**East Midlands Gateway
Phase 2 (EMG2)**

Application Documents Tracker

The East Midlands Gateway Phase 2 and Highway Order 202X

CHANGE LOG - DEADLINE 4

ACTIVE TRAVEL LINK (SECTION A) LONGSECTION
SCALE: H 1:2500, V 1:500. DATUM: 85.000

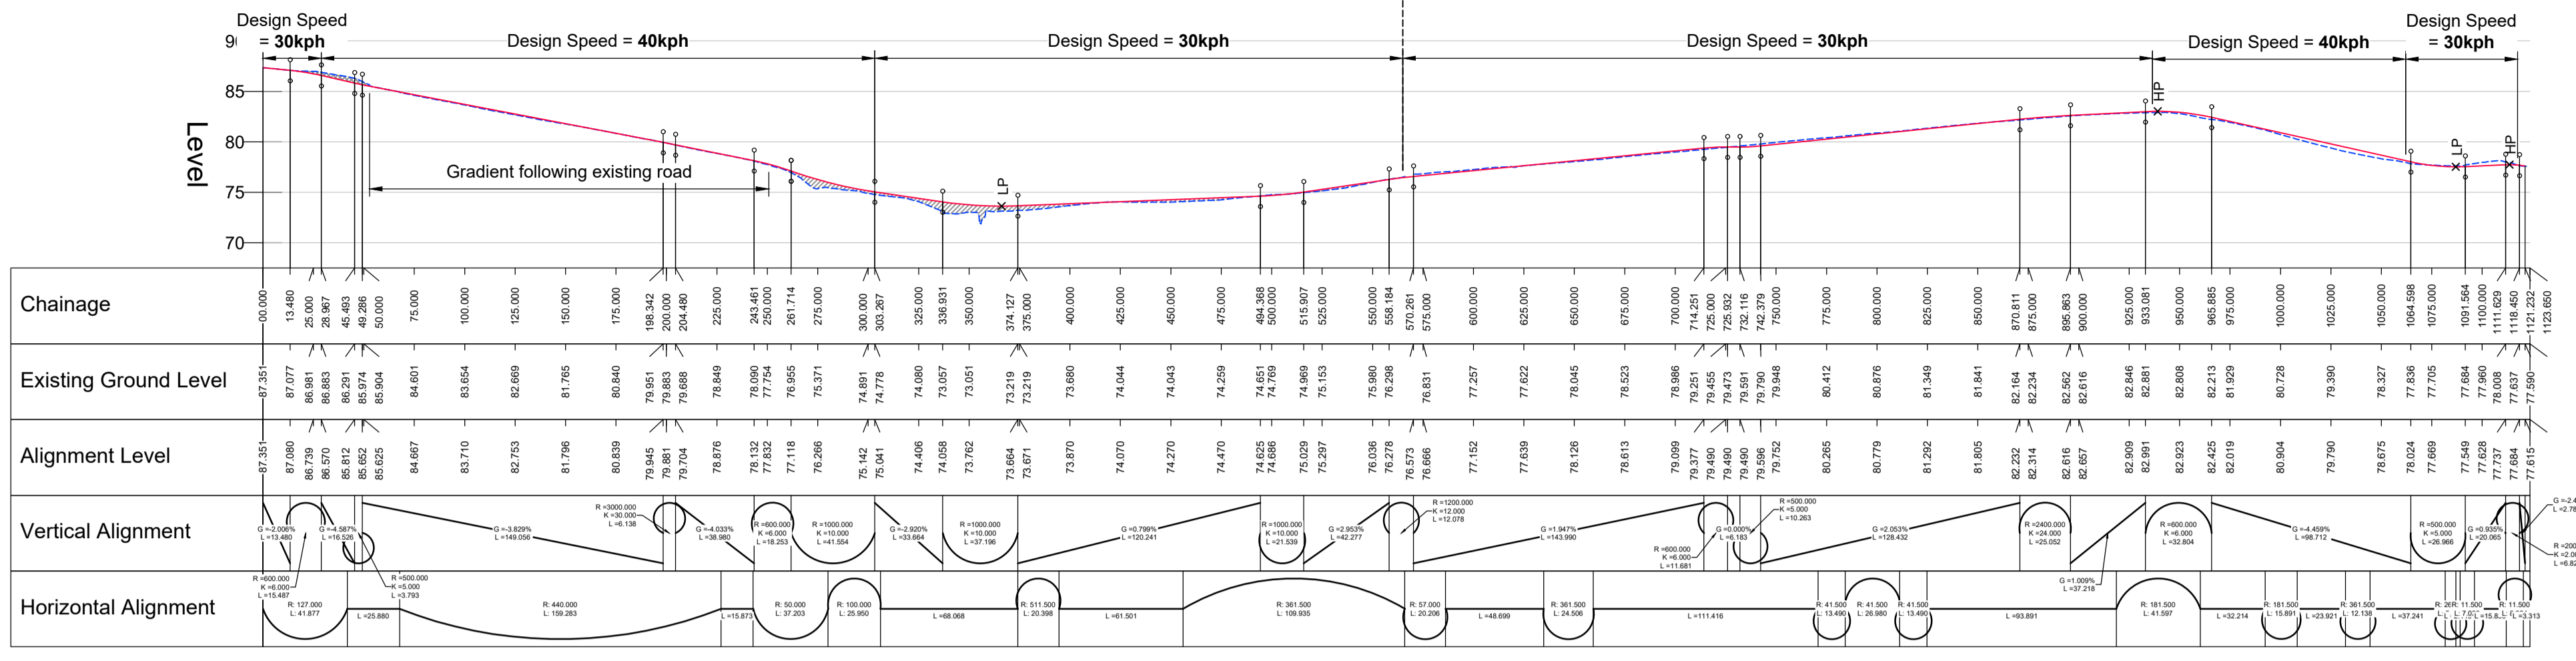
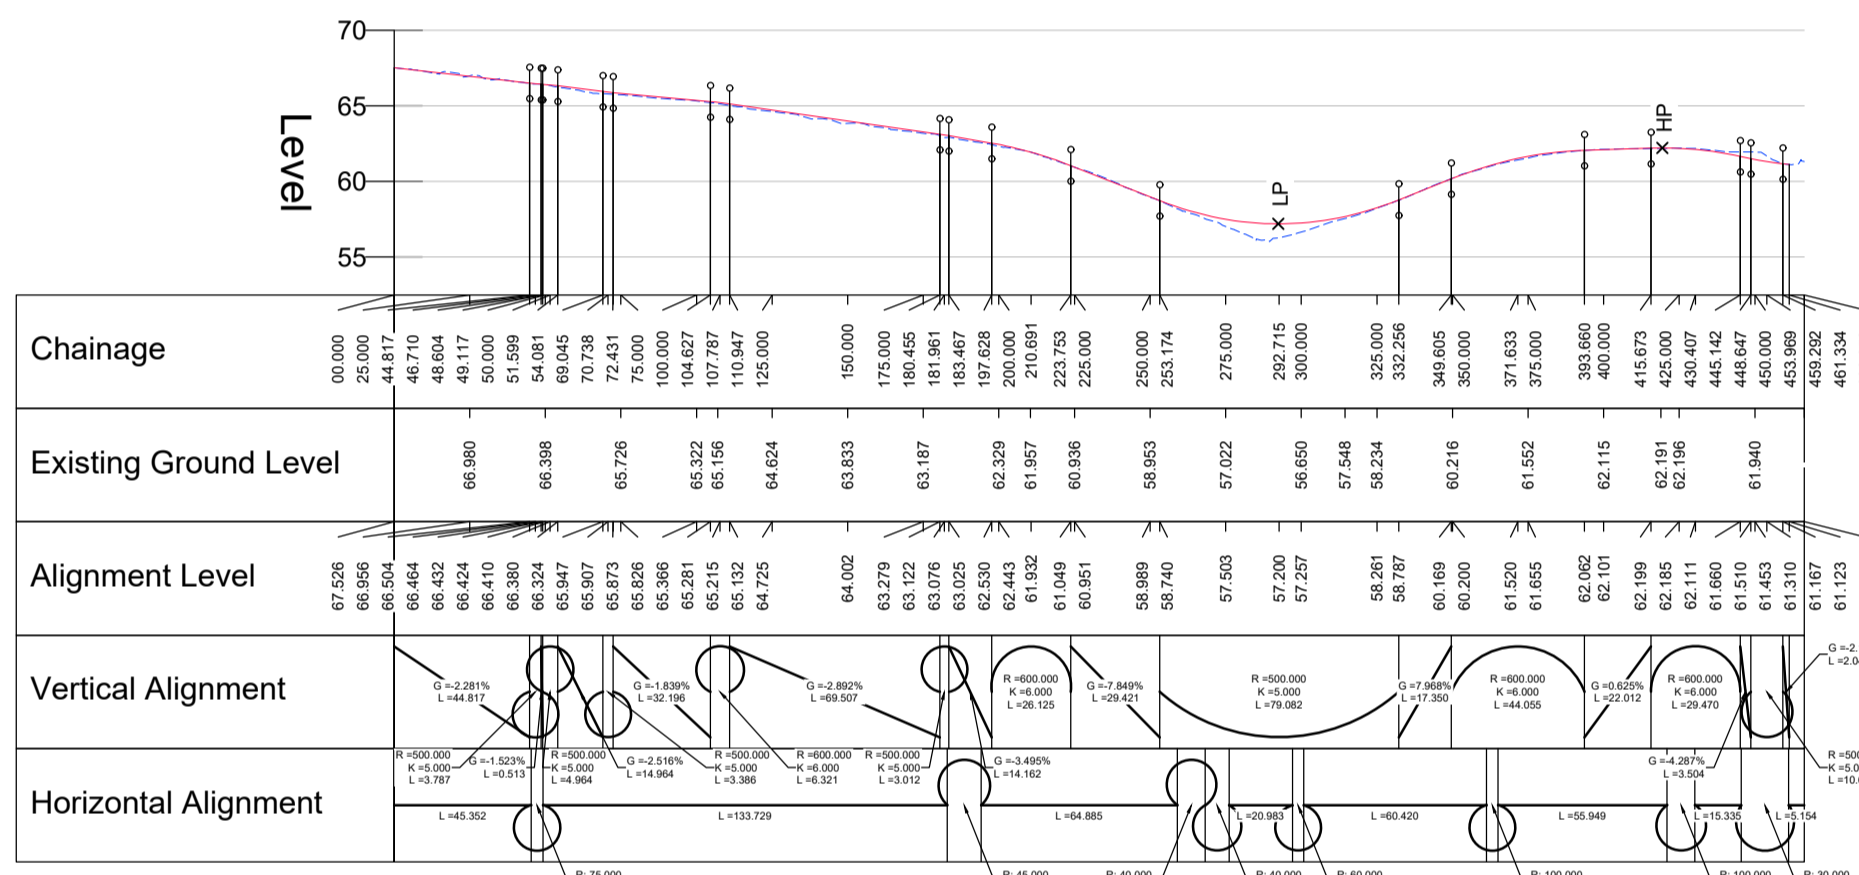
No.	Document updated since Deadline 3	Summary of Change to Document	Reason for Change to Document
			[REP2-046] [REP3-058]
9.	Highway Plans Long Sections Sheet 3 DCO 2.10C [APP-051D]	Amendment to reflect the revised alignment of the Active Travel Link.	The Applicants have agreed to make this change in response to the Deadline 2 and Deadline 3 submissions made by Leicestershire County Council. [REP2-046] [REP3-058]
